**Consultation Response from KC,
Trees**

2023/92966 Land to the rear of, 271, Cliffe Lane, Gomersal, Cleckheaton, BD19 4SB

Demolition of existing dwelling and erection of 87 dwellings including formation of a new access from Cliffe Lane, landscaping, public open space and all associated infrastructure and engineering works

Date Responded: 19/06/2024

Refer to Landscape plan PWP 752 002 01 Outline Landscape Masterplan and Specification

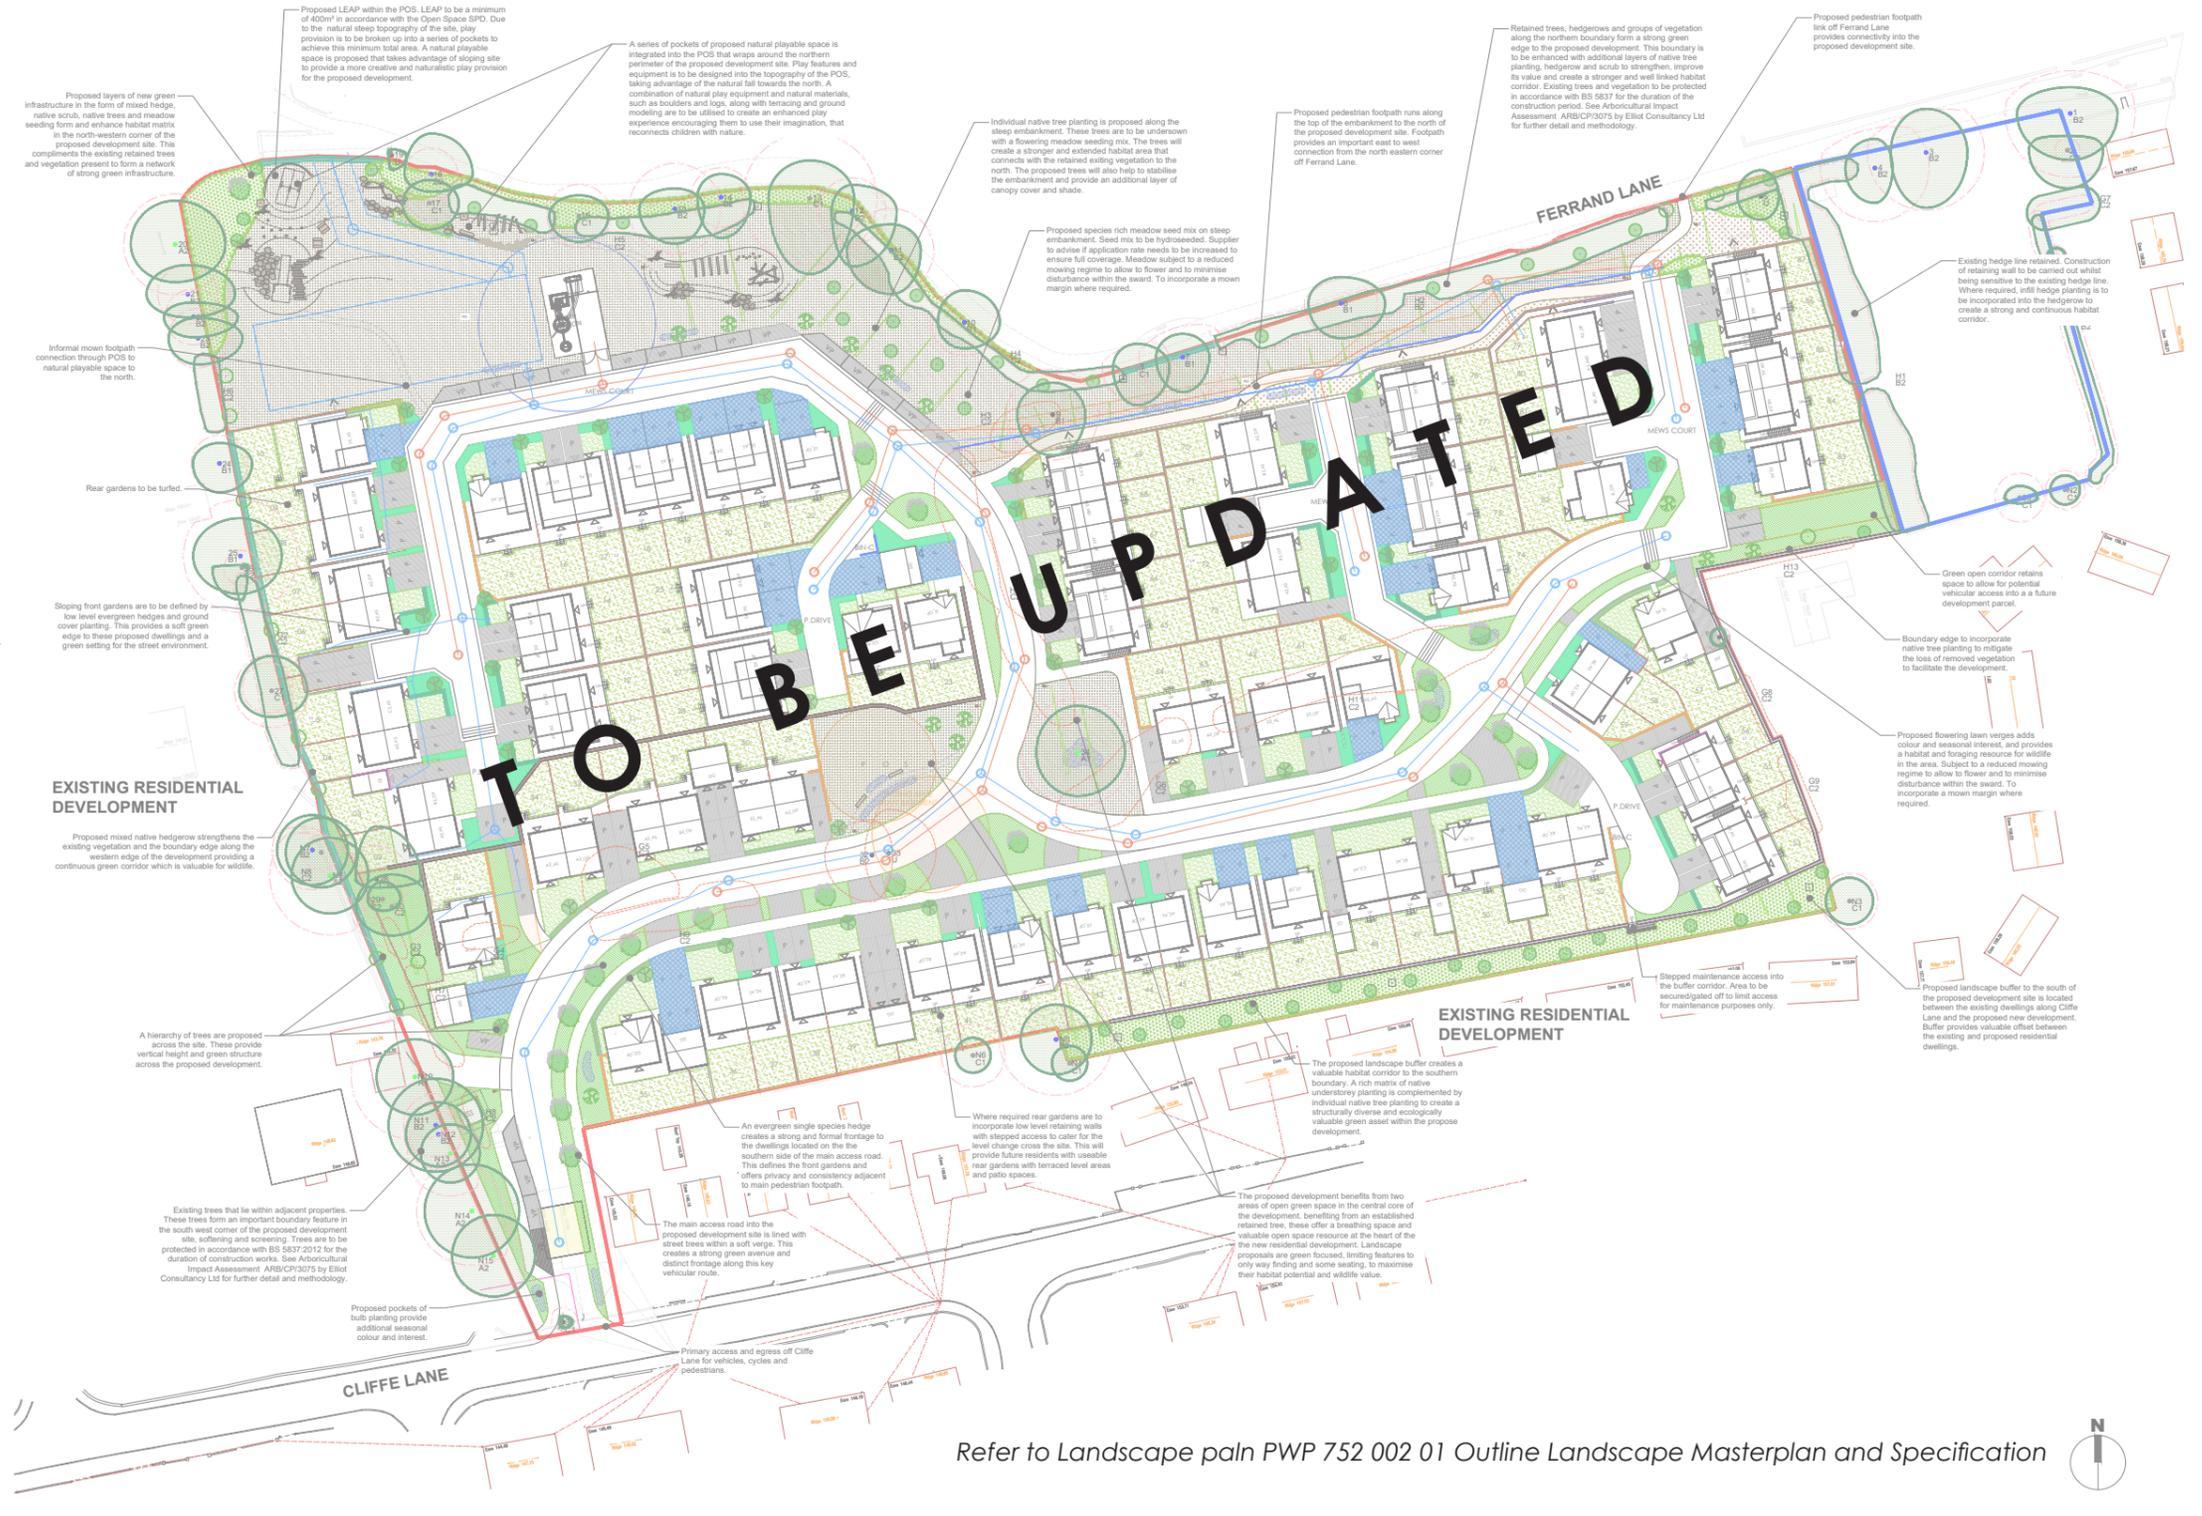
There is a concern over the discrepancy between the Arboricultural Impact Plan ARB/CP/3075/AIP and the Outline Landscape Master Plan PWP 752 002. Tree T9 is a protected tree and should be retained. T9 shows on the Outline Landscape Master Plan but is down for removal on the Arboricultural Impact Plan. The retention of this tree is feasible and should be prioritized due to its status as a protected tree. There has also been no Arboricultural Method Statement submitted which would detail the protection of retained trees during construction and the schedule of events that the project arborist would visit site/supervise sensitive work around RPAs

The discrepancy over T9 is amended and shown as retained.
